**re: Preliminary Geotechnical Review - Proposed SWMP**  
**Proposed Residential Development**  
**Cardinal Creek Village South – Ottawa, Ontario**

**to:** Taggart Investments - **Ms. Michelle Taggart** - [mtaggart@taggart.ca](mailto:mtaggart@taggart.ca)  
**to:** HP Urban Inc. - **Mr. Peter Hume** - [peter.hume@hpurban.ca](mailto:peter.hume@hpurban.ca)  
**to:** DSEL - **Mr. Braden Kaminski** - [Bkaminski@dsel.ca](mailto:Bkaminski@dsel.ca)  
**date:** December 2, 2022  
**file:** PG5201-MEMO.01 Revision 2

Upon your request and authorization, Paterson Group (Paterson) prepared a preliminary geotechnical review of the proposed stormwater management pond (SWMP) to be located at the north side of Cardinal Creek within aforementioned development. This memo should be read in conjunction with Paterson geotechnical Report PG5201-1 Revision 5 dated November 29, 2021.

SECTION 1-1
SCALE HOR: 1:250
VER: 1:100

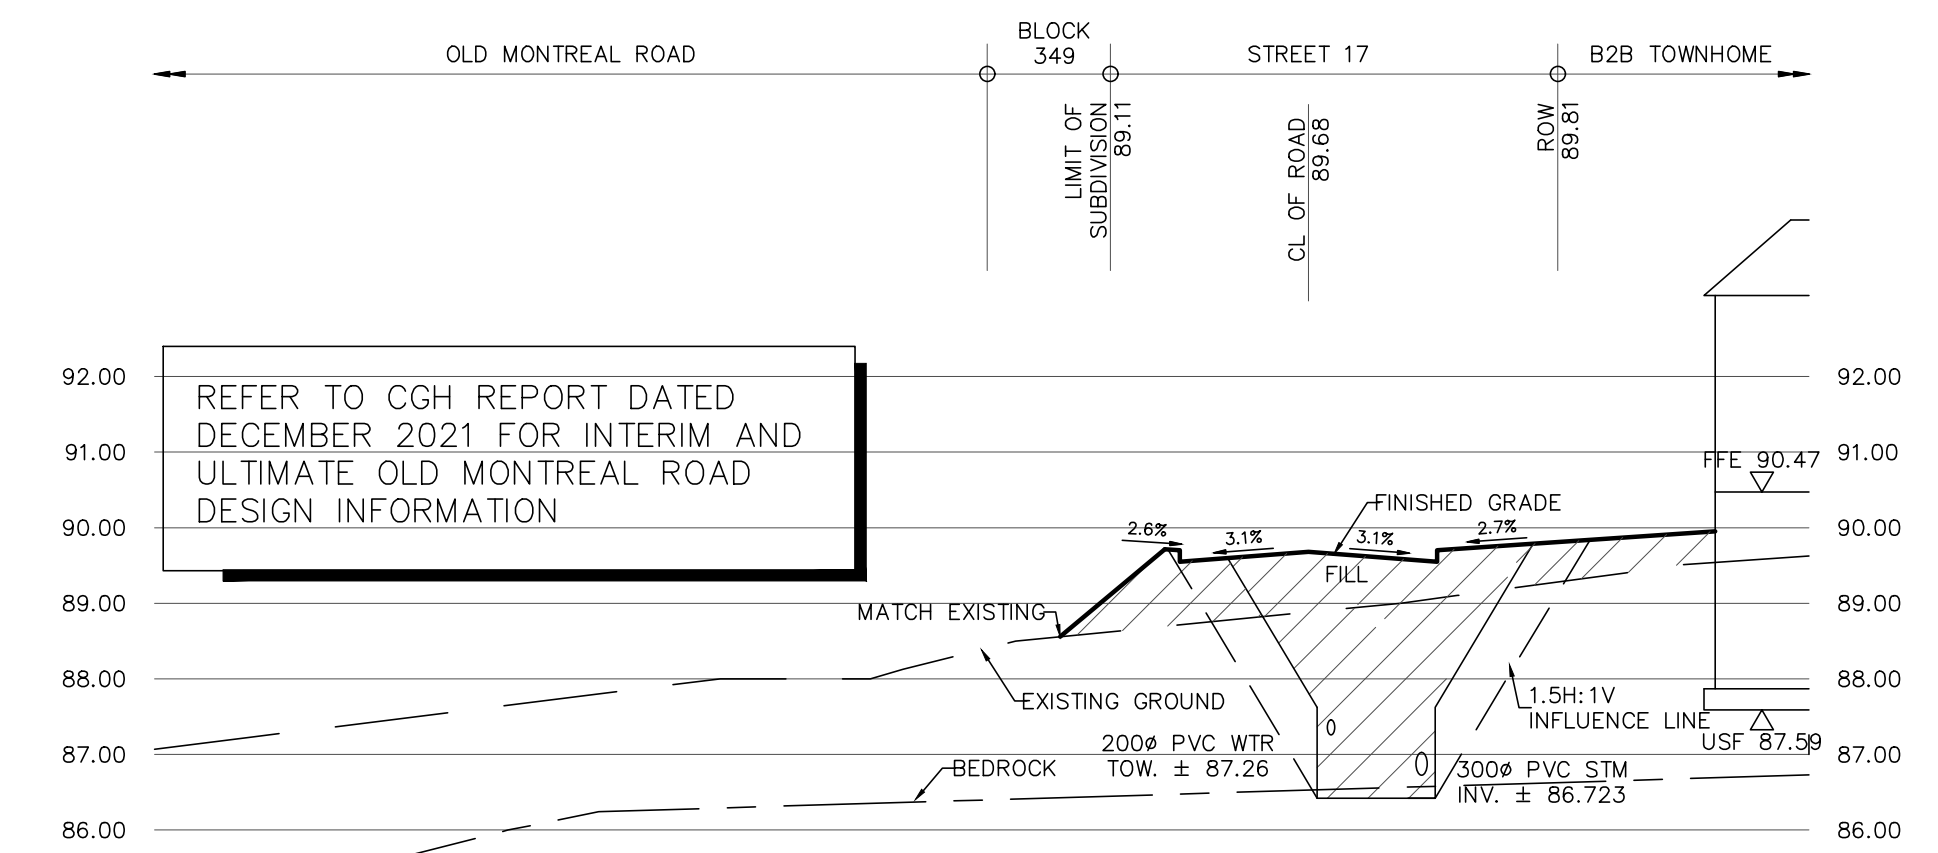
Paterson reviewed the current preliminary design drawings for the SWMP outlet structure (attached to the end of this memo). Based on our review, the proposed concrete headwall and outlet structures will be founded on Stiff grey silty clay and/or inferred glacial till. The bearing resistance values for the proposed structures can be taken from the "bearing capacity for concrete structures" section in the previous page.

The Spillway fronting the pond outlet pipe is proposed to be terraced with armour stone blocks. It is recommended that the armour stone blocks be placed on a sufficient bearing medium. The bearing medium should be cut back in a stepped fashion down to the edge of the Cardinal Creek stream. If bedrock is encountered at the bottom of excavation, bedrock removal may be required to accommodate the stepped subgrade recommended herein. Each step should be cut a minimum 1.2 m horizontally and maximum 0.6 m vertically. If soil is encountered at the steps, a non-woven geotextile liner such as Terrafix 270R or equivalent, should be used to cover the subgrade. The subgrade should be built up to the underside of the armour stone using OPSS Granular A crushed stone or Granular B Type II placed in maximum 300 mm thick loose lifts and compacted to a minimum 98% of the material's SPMDD.

The armour stone blocks should be backfilled with engineered fill such as OPSS Granular A or Granular B Type II compacted to a minimum 95% of the material's SPMDD. The armour stone blocks should be placed staggered in a Piano-key fashion and battered at a minimum 100 mm between rows to enhance the overall global stability of the system. Due to the nature of armour stone blocks, the blocks will be in different sizes and shapes and may form voids between the blocks. Therefore, it is recommended that non-woven geotextile liners such as Terrafix 270R or equivalent, be placed between the armour stone blocks and the backfill material to prevent the loss of the backfill material.

If the bottom concrete headwall is founded over silty clay or glacial till, it is highly recommended that riprap stone be placed against the bottom of the headwall structure to prevent the running water from undermining the headwall footings until the armour stone wall system is constructed. The riprap stone should consist of stone fragmented to maximum size of 400 mm with sharp edges to allow for interlocking between the riprap material.

SECTION 3-3
SCALE HOR: 1:250
VER: 1:100

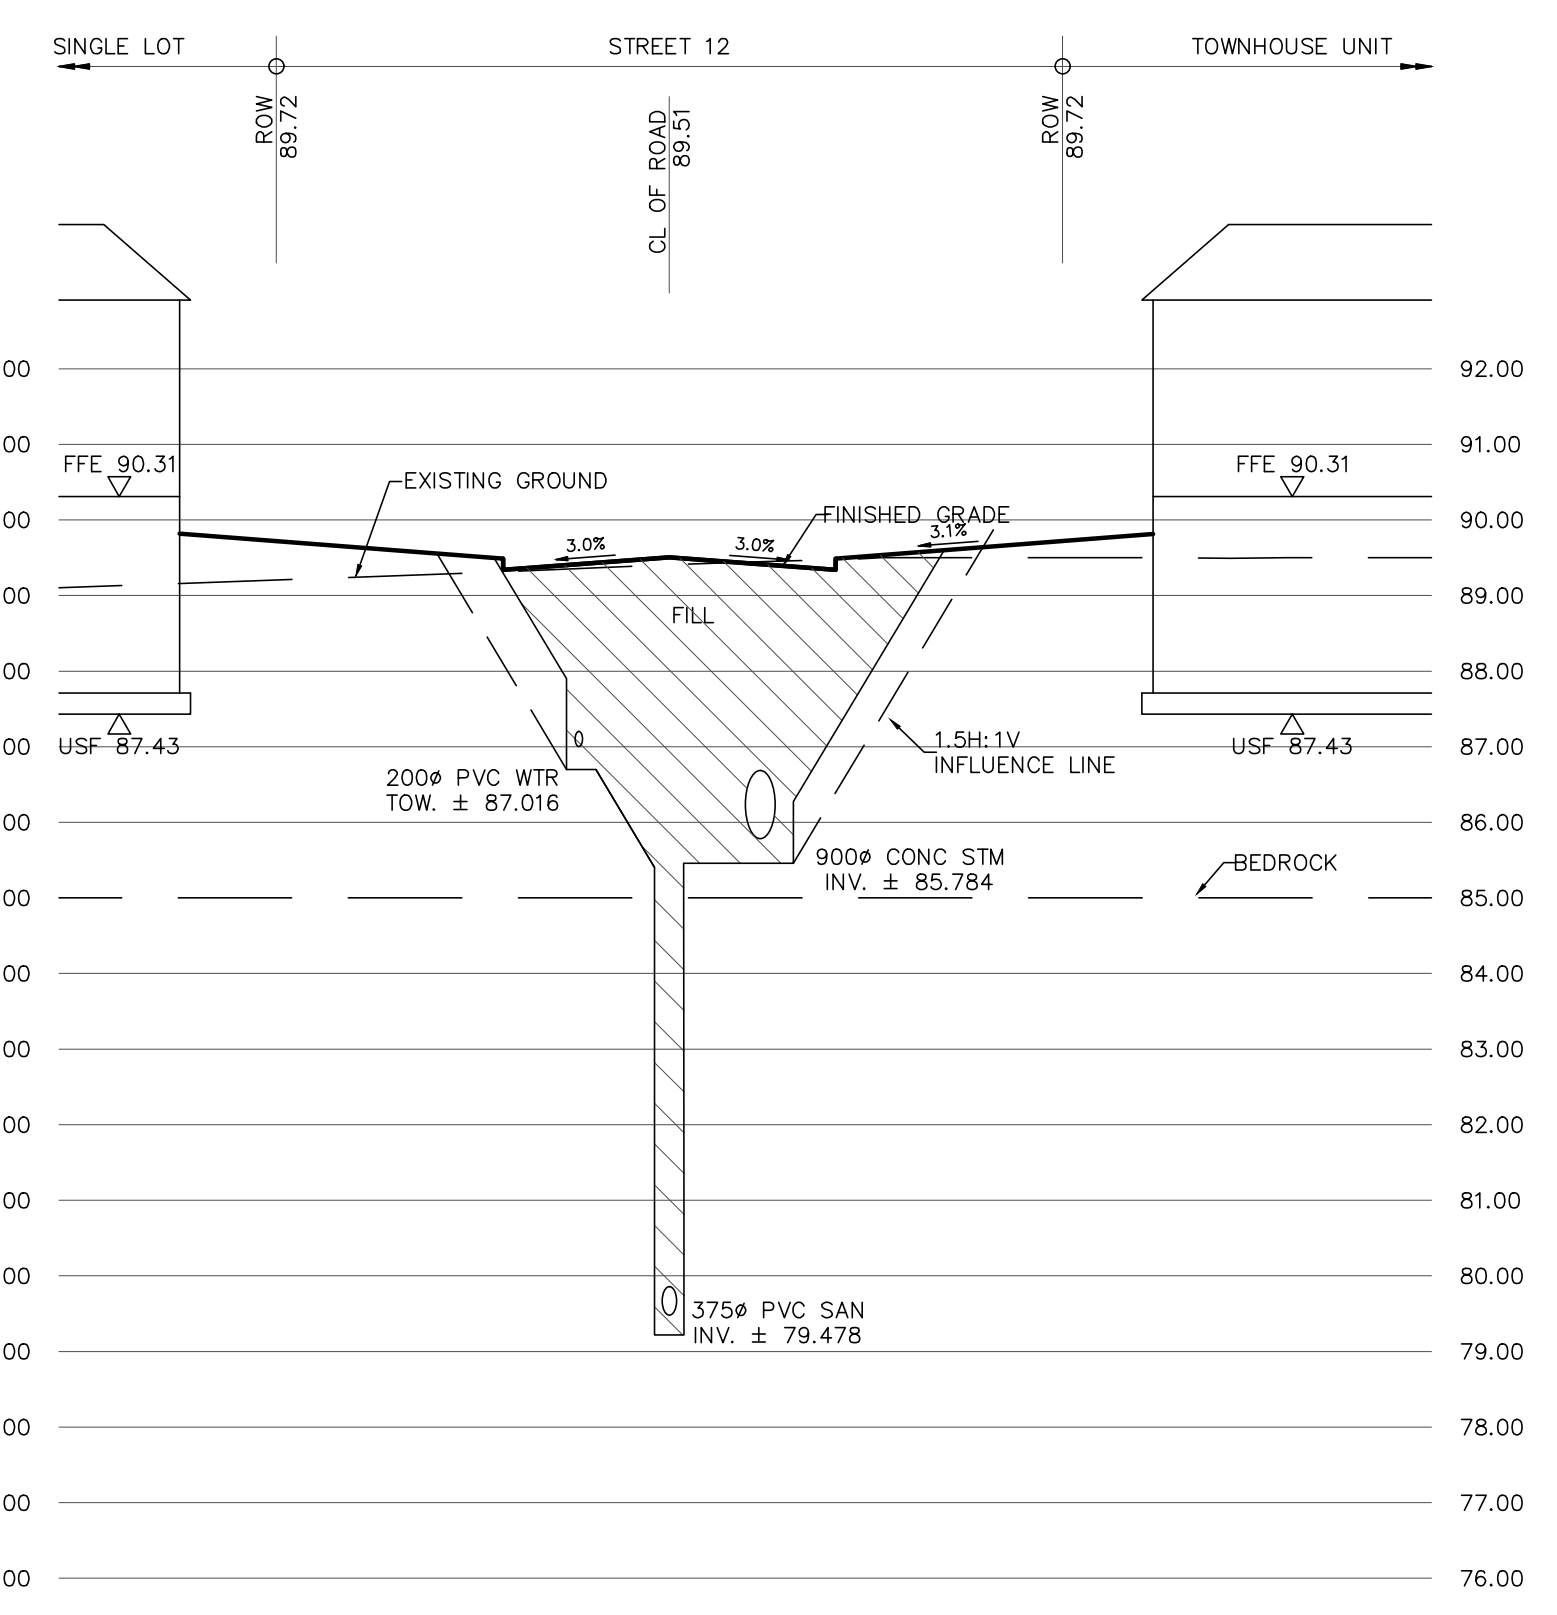
From a geotechnical perspective, the construction of the proposed SWMP is sufficient. The long-term performance of the subject pond will depend on the stability of its excavation side slopes. Due to the absence of finalized grading, the sidewalls of the pond should be cut back at a 3H:1V to 5H:1V side slope to ensure long term stability is maintained for the service life of the proposed SWMP.

If steeper slopes are proposed for the SWMP, additional slope reinforcement system will be required such as erosion control blankets with hydroseeding or Geocells such as Presto GEOWEB or an approved alternative. The recommended slope stabilization system will be dependent on the steepness of the proposed side slopes which can be reviewed upon finalizing the SWMP design drawings.
